Our Case Number: ABP-314942-22

Re: BusConnects Lucan to City Centre Core Bus Corridor Scheme
Lucan to Dublin City Centre

SUBMISSION IN RESPECT OF
THE LUCAN TO CITY CENTRE BUS CORRIDOR

Gareth Kelly of 74 Palmerstown Drive, Palmerstown, Dublin 20 (D20HX98)

Sheet 11 of 40

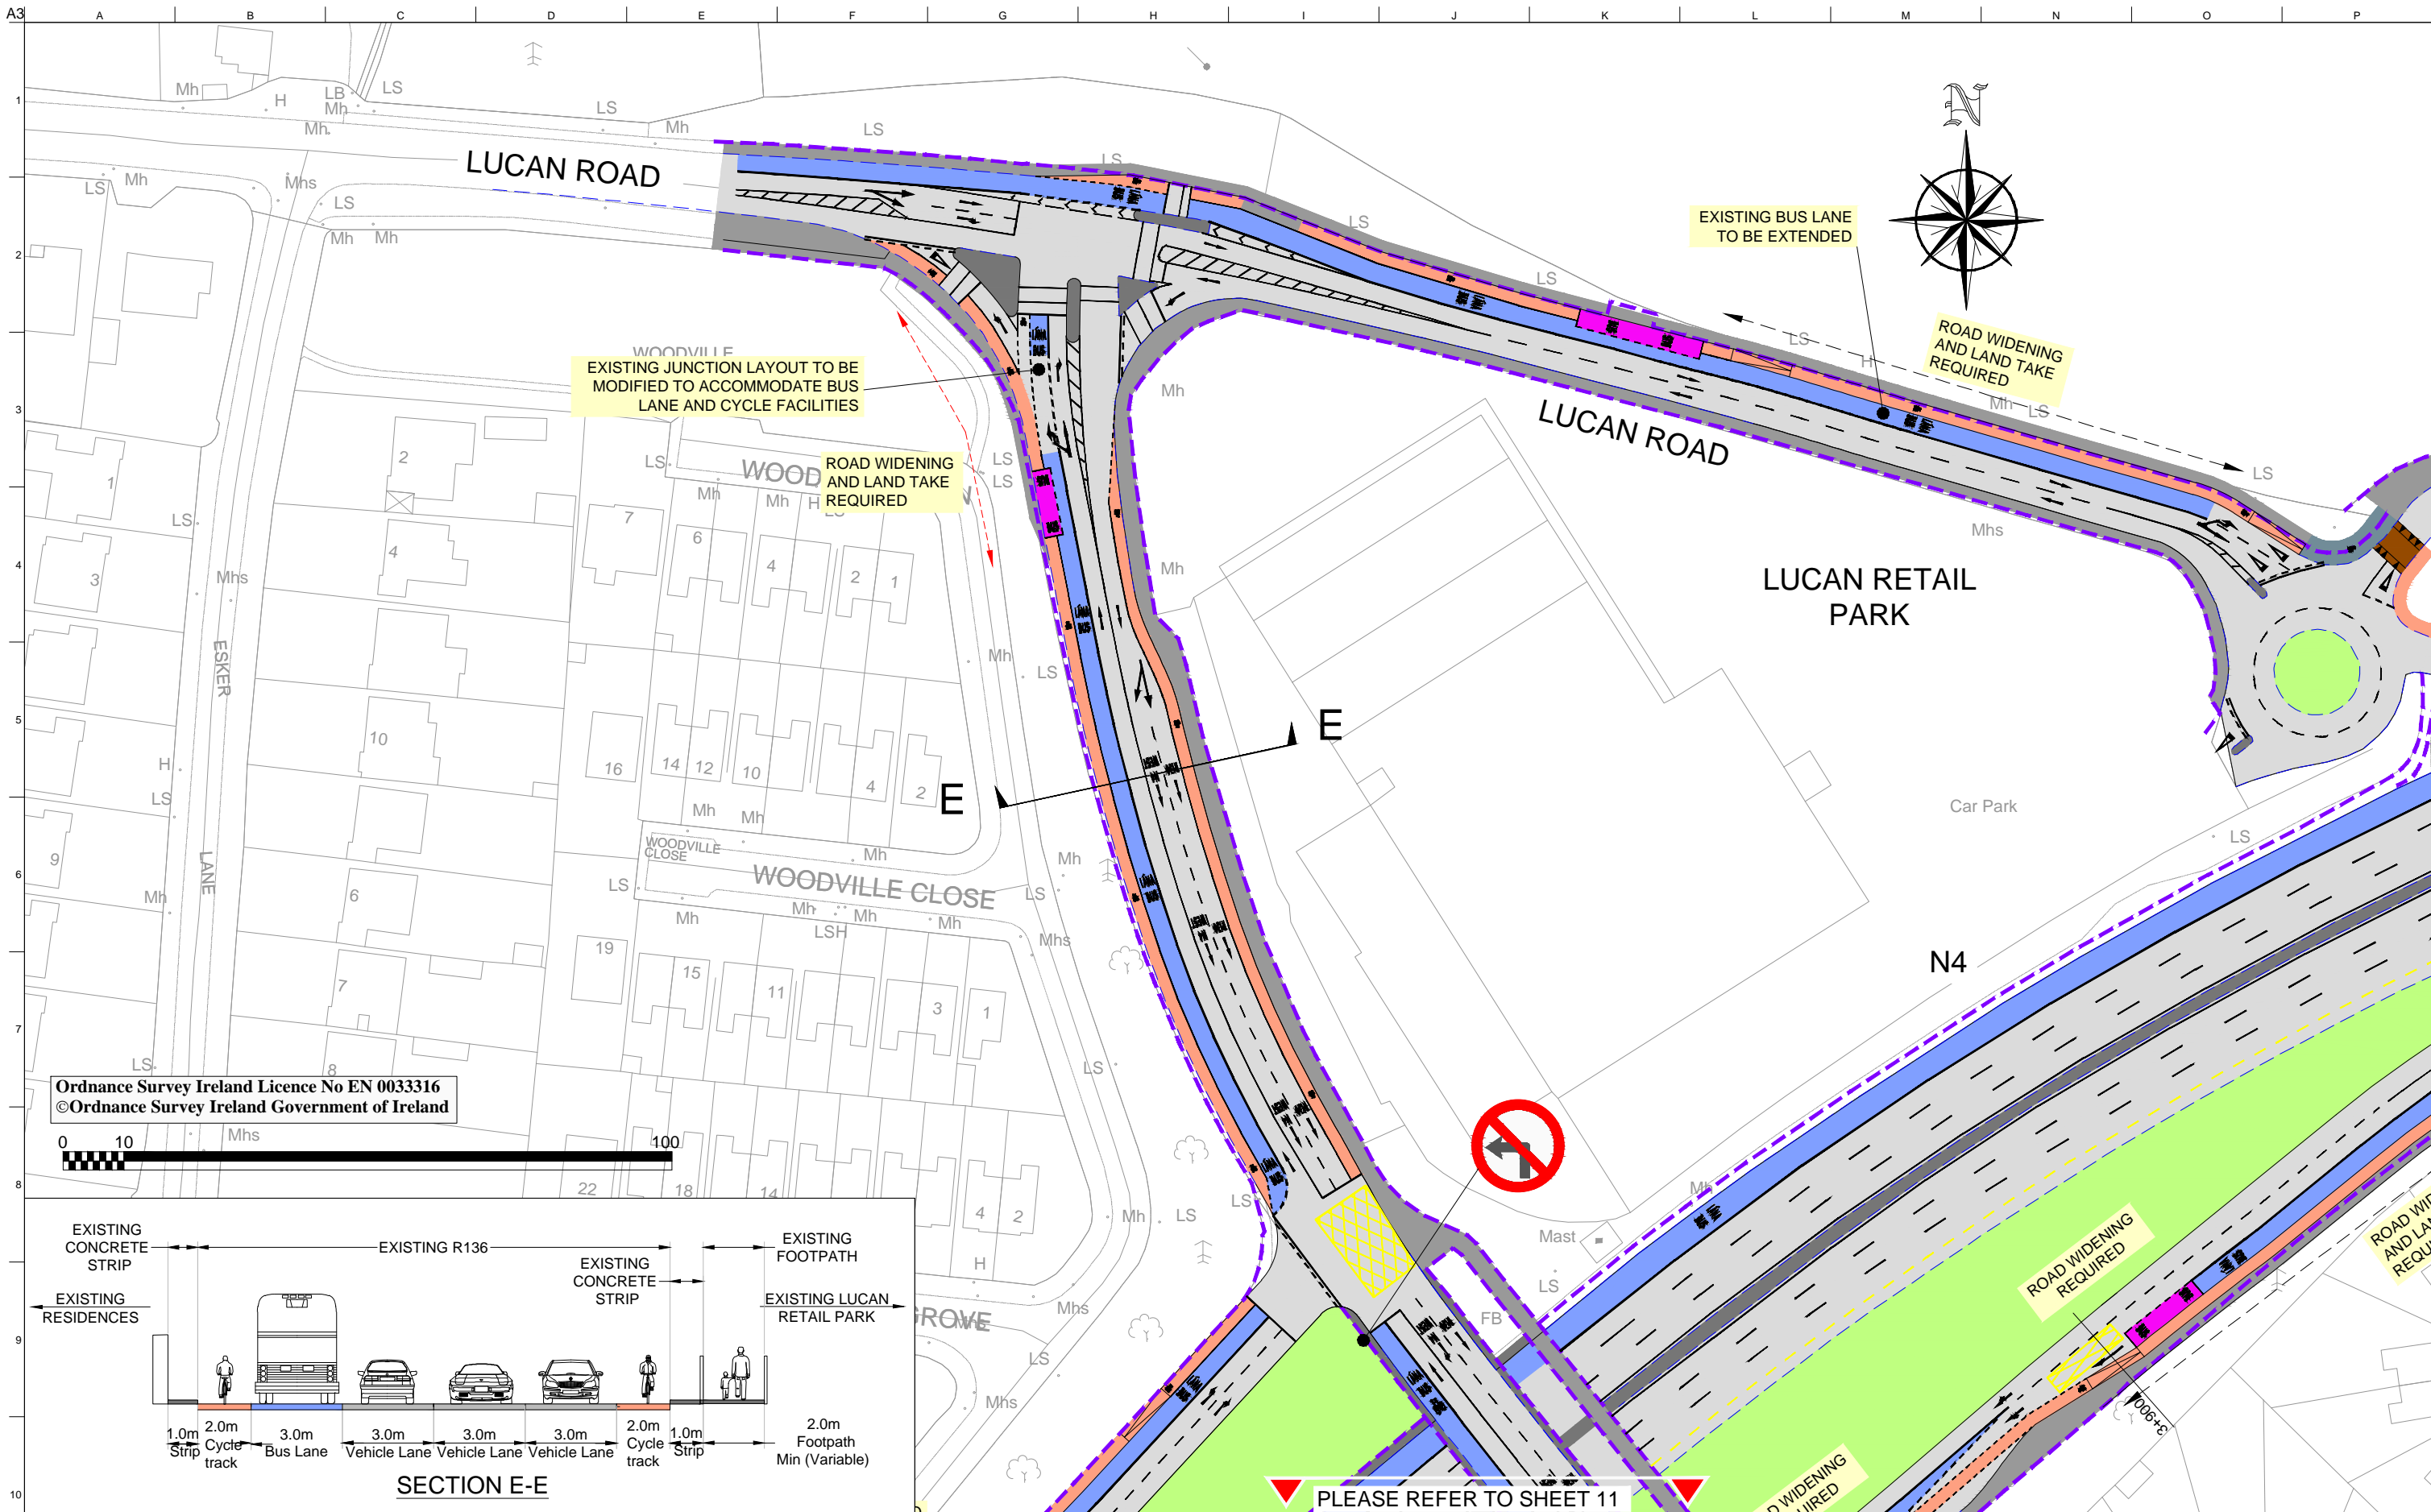
5. The existing pedestrian and cycle bridge across the M50, shown on sheet 11 (see below) is simply not wide enough for a two way cycle lane and a two way walkway proposed. Considering the distance recommend leaving a cyclist by a car in zones up to 50km is one meter (www.rsa.ie) this would seem to mean two cyclist travelling at a speed of up to 25kph in opposite direction would need a 3 meter wide cycleway. Therefore, there is insufficient room for two pedestrians or indeed wheelchair users to safely to pass each other on this bridge when cyclists are travelling in two-way directions. As such further infrastructure possibly even a replacement or additional bridge needs to be considered to properly and safely benefit cyclists, wheelchair users, mobility scooters and pedestrians. It seems disproportionate that a Compulsory Purchase Order is being proposed to straighten a few yards of a footpath at the Kennelsfort junction, yet it is proposed to leave the cycle route and pedestrian route over the M50 in a very poor zigzagging layout with very obvious safety implications for both pedestrians, cyclists and wheelchair/mobility scooter users.
